Ref: 00134485

RE: NON MATERIAL AMENDMENT TO PREVIOUSLY APPROVED SCHEME A/53/12/ ON LAND SOUTH OF MILL COTTAGE, OLD MILL LANE, ANGMERING

PROPOSED SITE
DETAILS

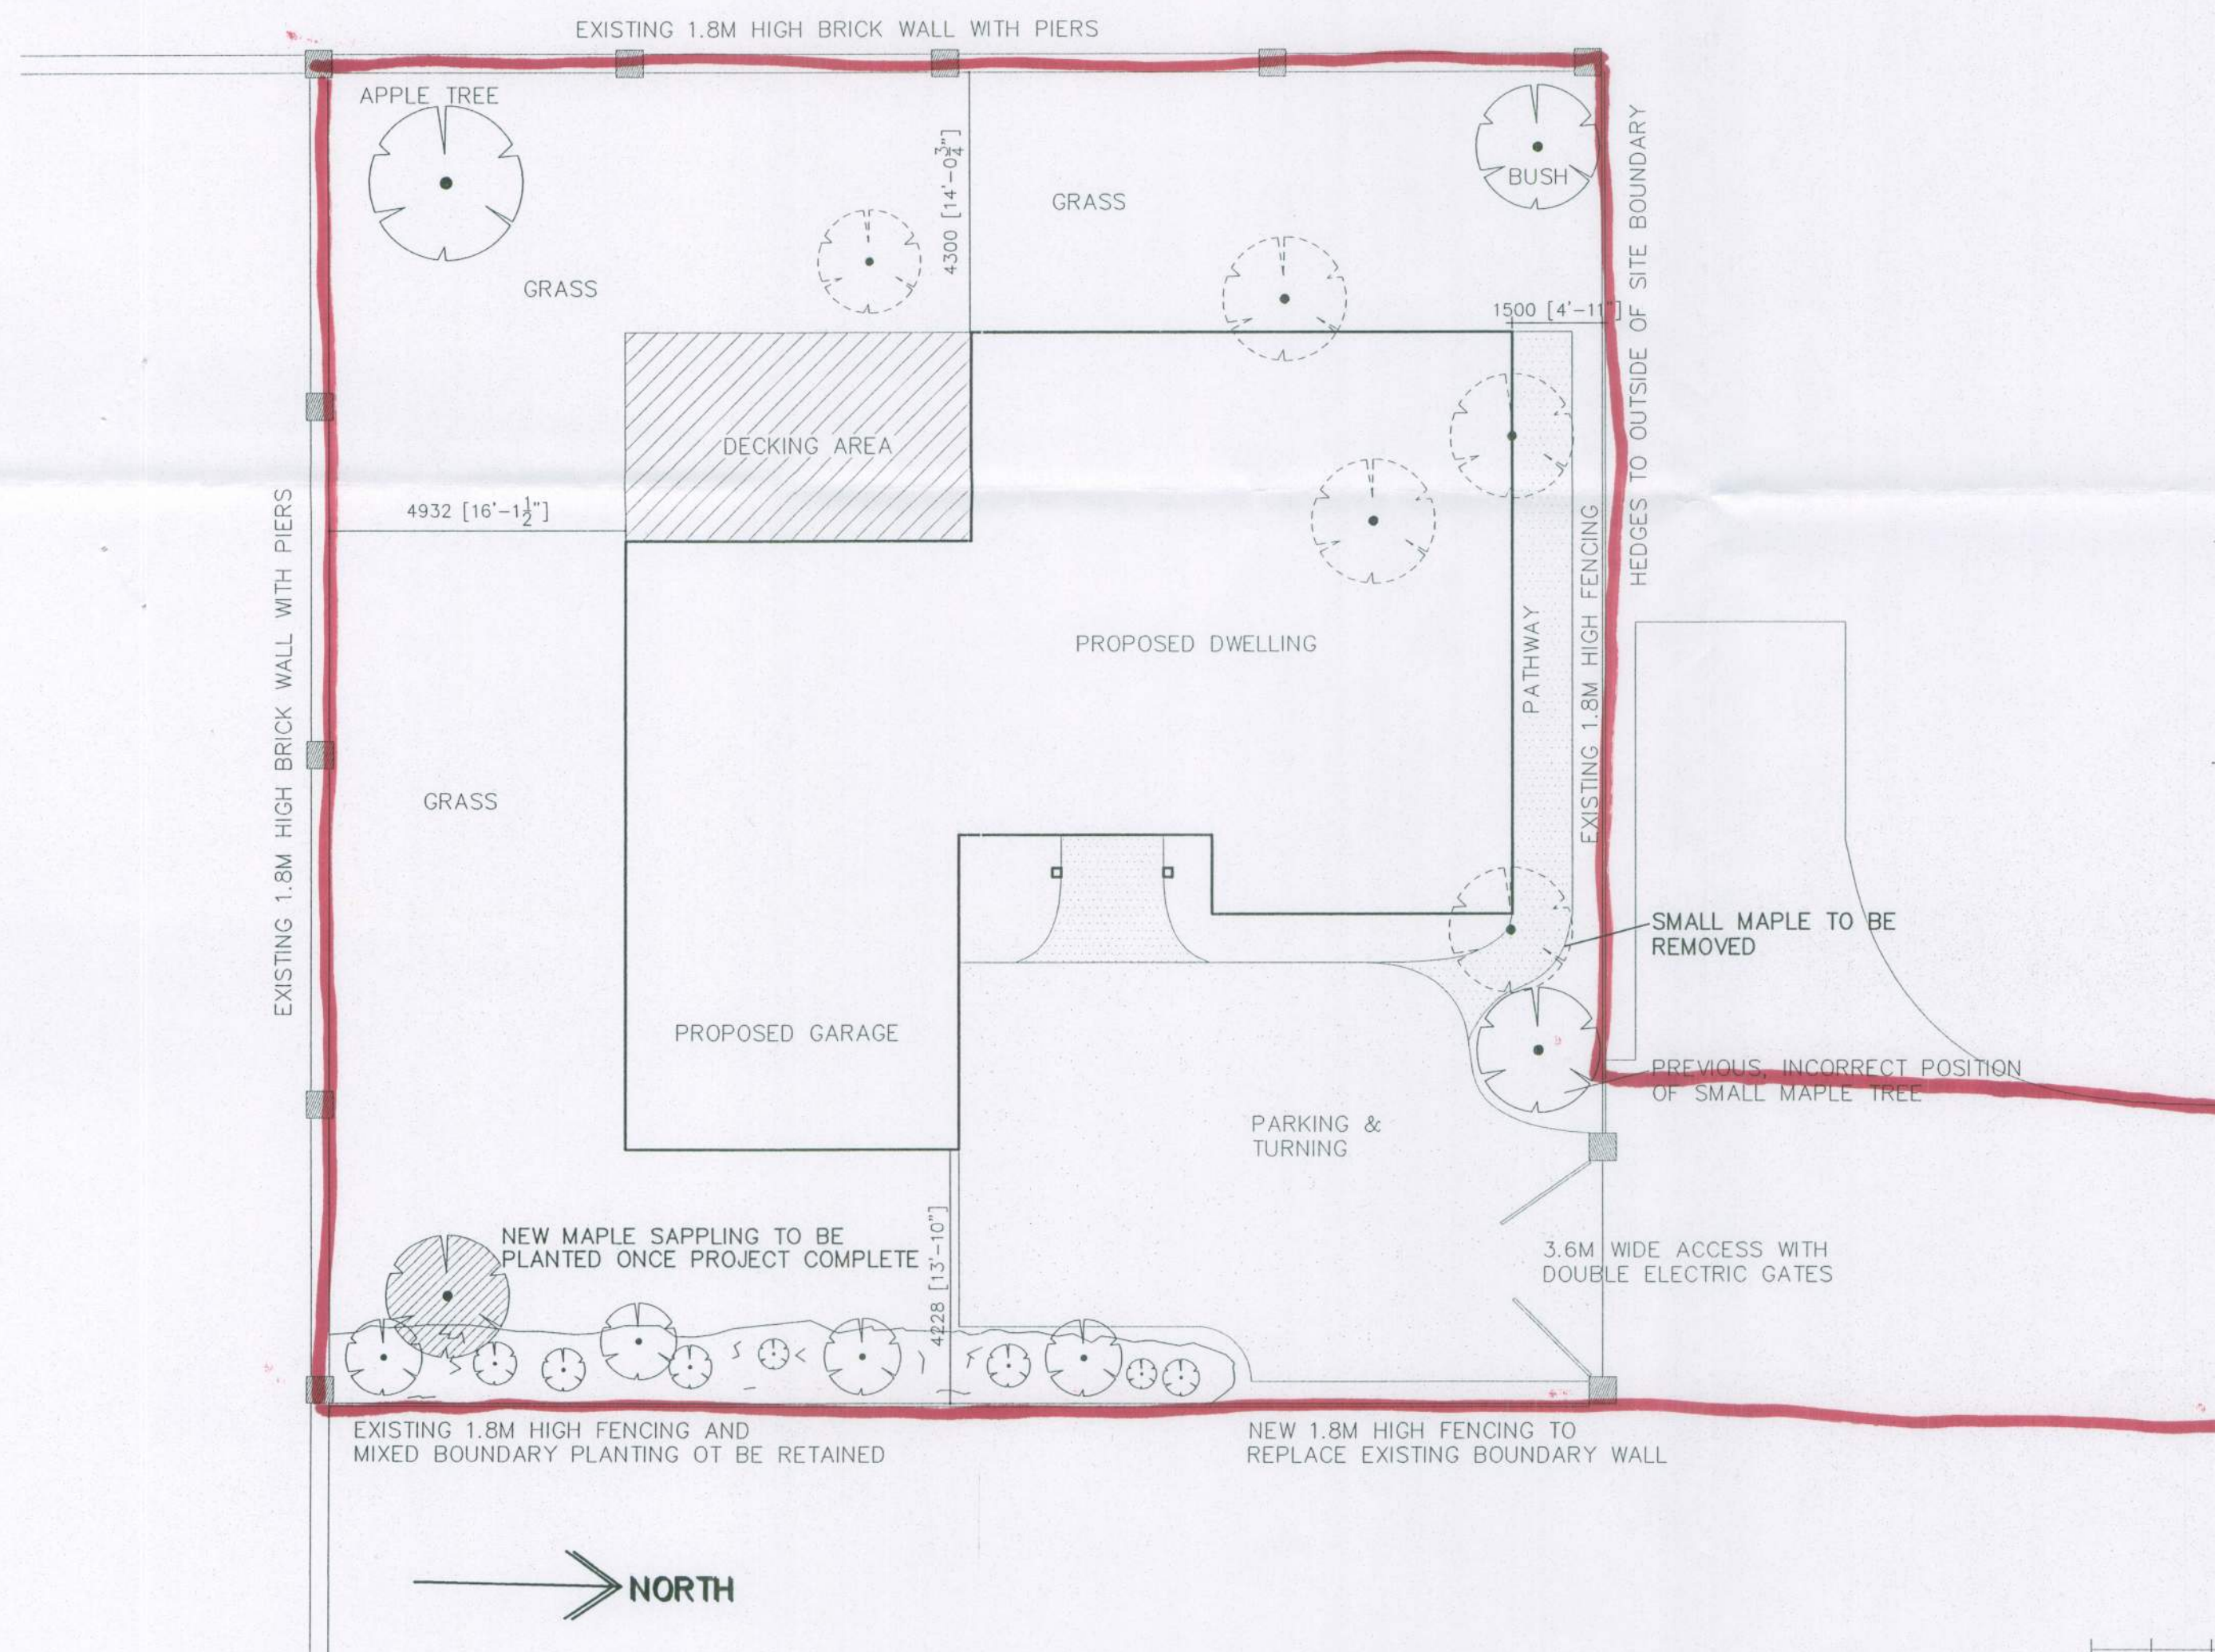
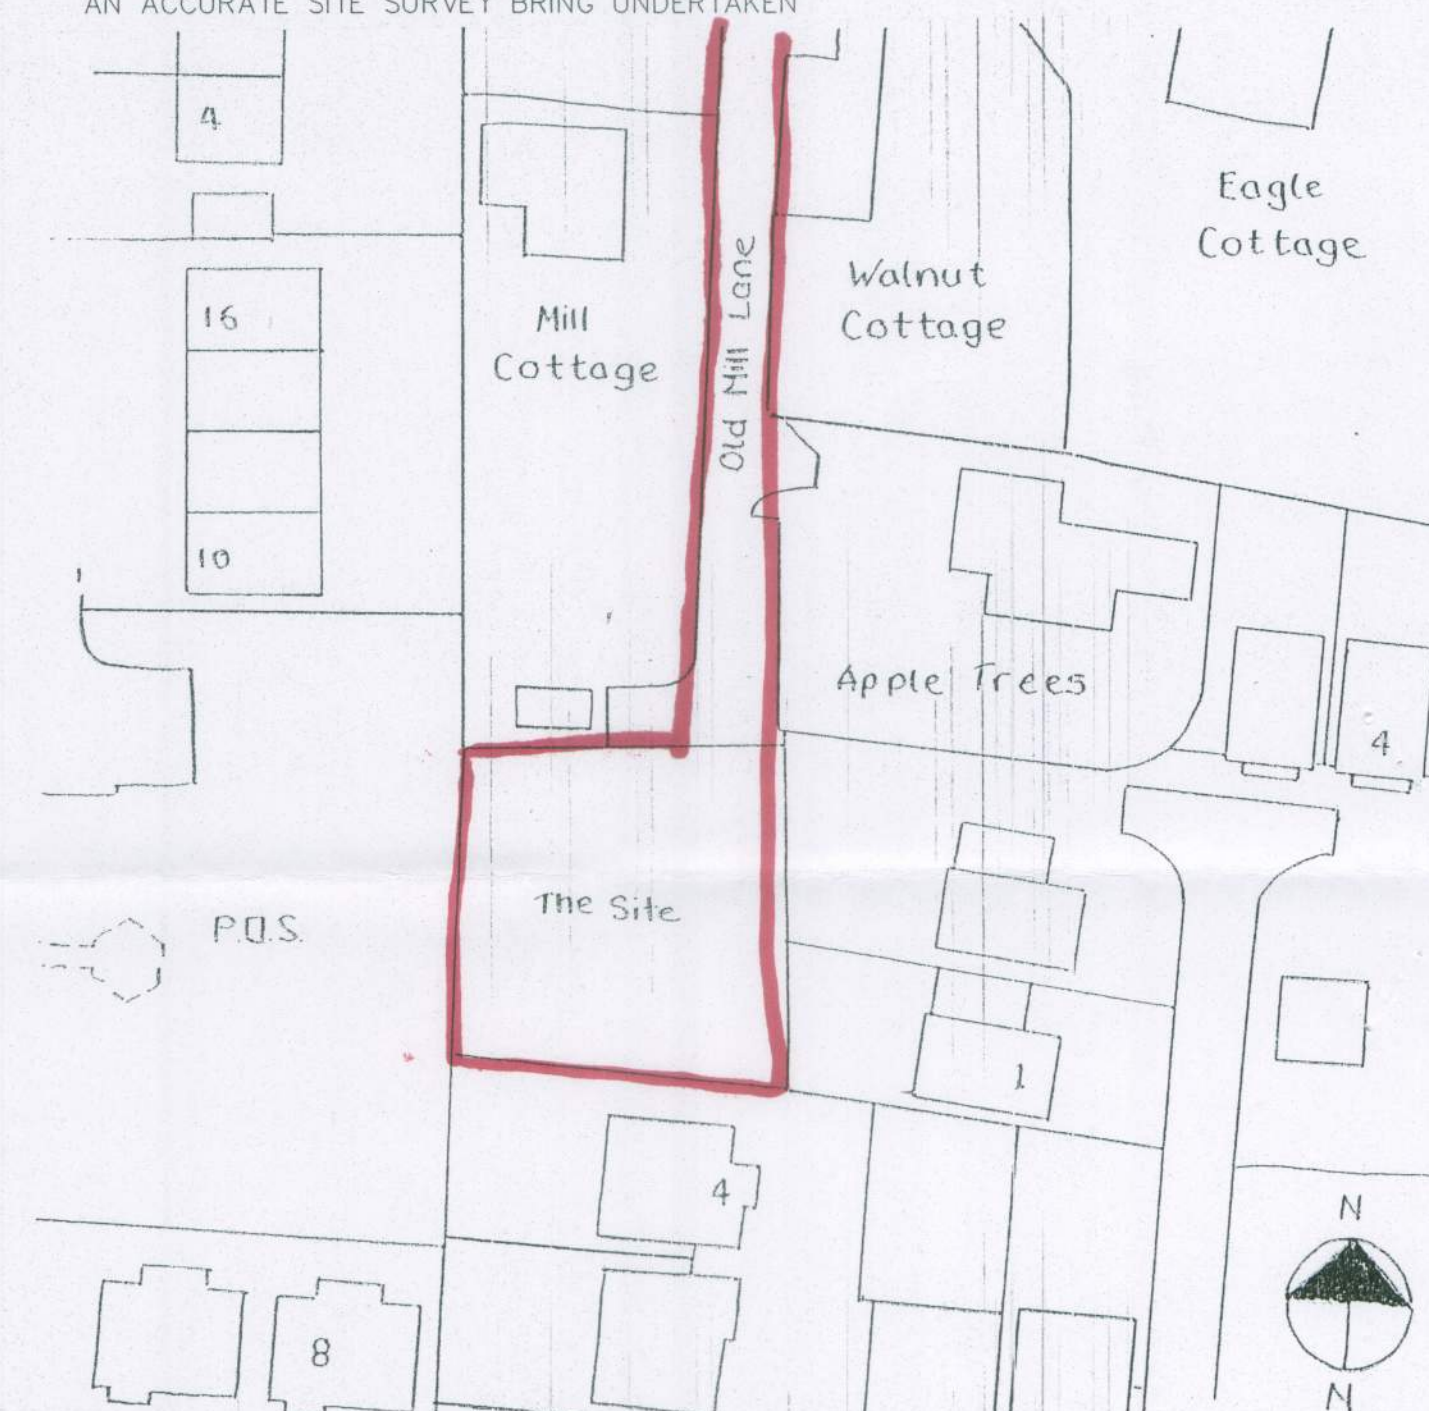
The maple tree related to this amendment was detailed in an incorrect position on the submitted Site Plan. When the builder came to 'set out' the foundations for the approved scheme, it became apparently obvious that the maple tree would not survive the build due to the now extreme close proximity of its relationship with the dwelling.

The maple tree is not protected by a TPO, is not in a conservation area, offers no site screening and could not been seen from the High Street, it was therefore removed as part of the site clearance. A new maple sapling will be planted on the site once the build is completed and this is detailed on the enclosed plan.

It is regrettable that this tree had to be removed but it would not have survived the build process due to its roots being significantly damaged by the foundations and as such we will plant a new sapling within the site in a far more unobtrusive position.
